6 April 2017

File Number: SSD 7417
Our Ref: R/2017/4

**Regiment Mixed-Use Redevelopment Project at the University of Sydney,
Darlington Campus (SSD 7417)**

Ground Level - Tree Retention & Removal Plan

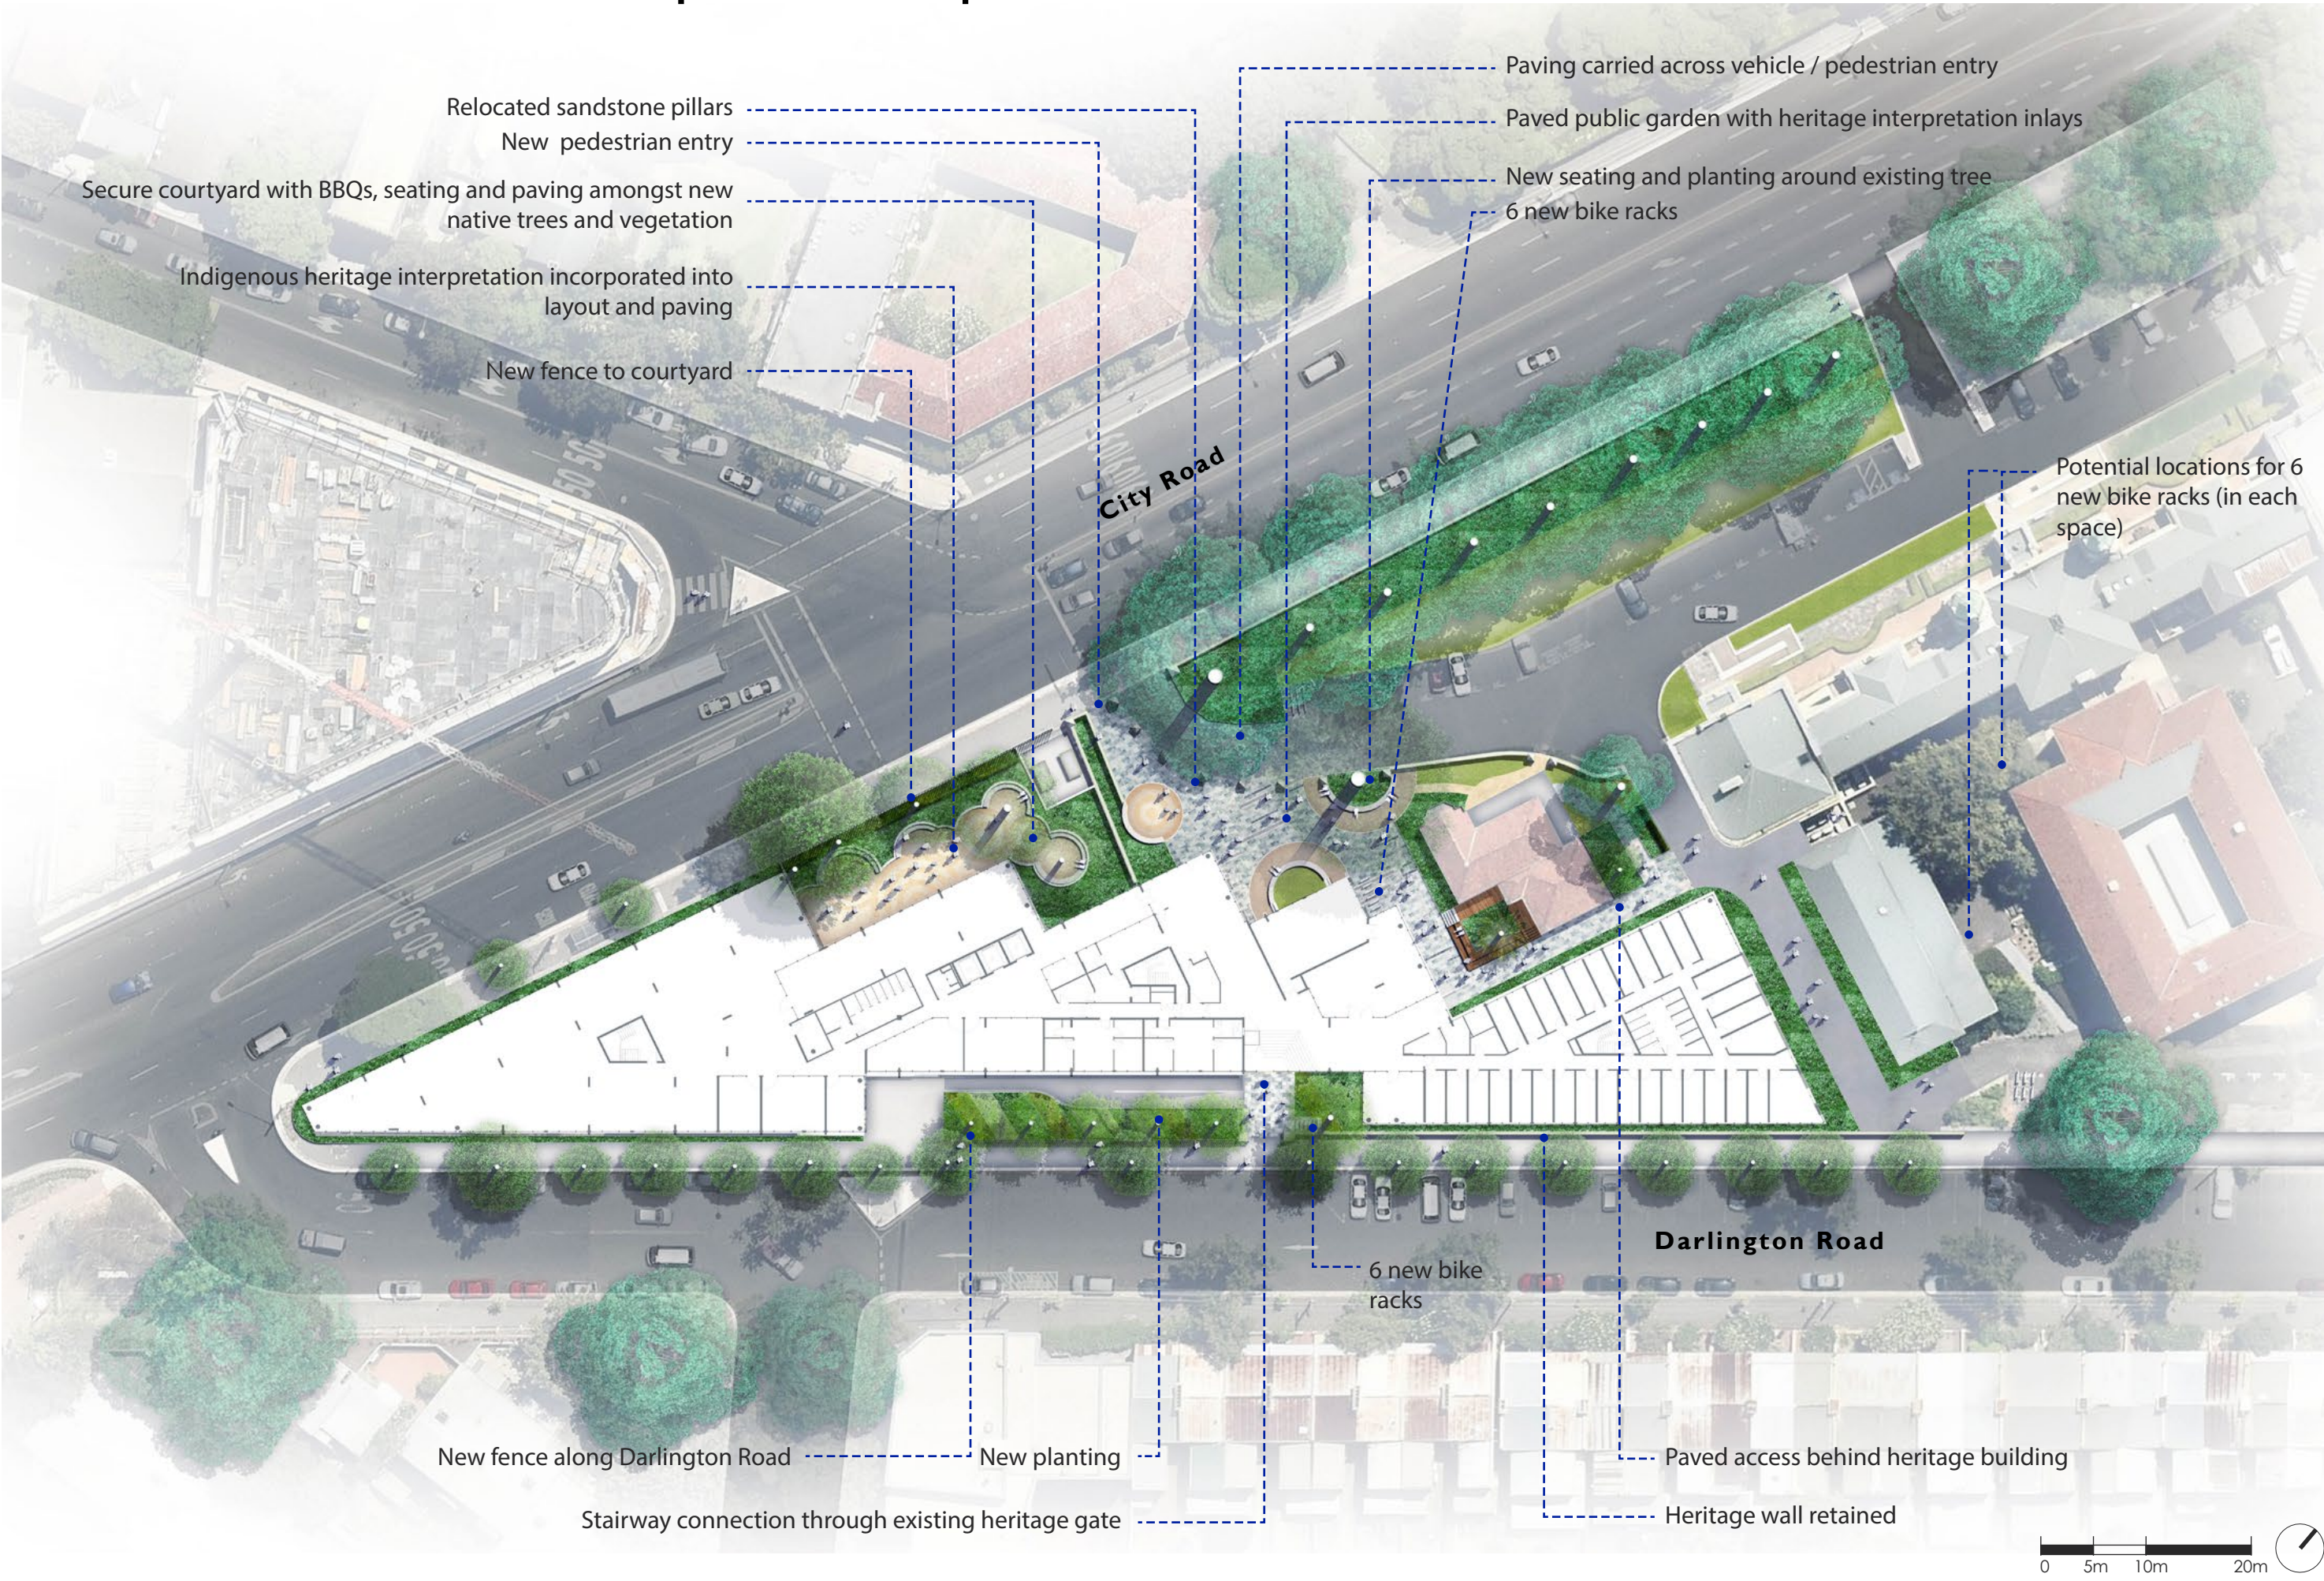
- Heritage, and the impact on the Superintendent's House, and the 1880's western boundary wall amongst others.
- Landscaping concept proposal and its relationship with the site and the existing and proposed buildings and existing significant Fig tree. In addition, the impact the landscaping design will have on the security of the site

- Insufficient detail within the submitted wind report, including assessment of all the terraces.
- Architectural resolution of the proposed building.
- Removal of street trees.
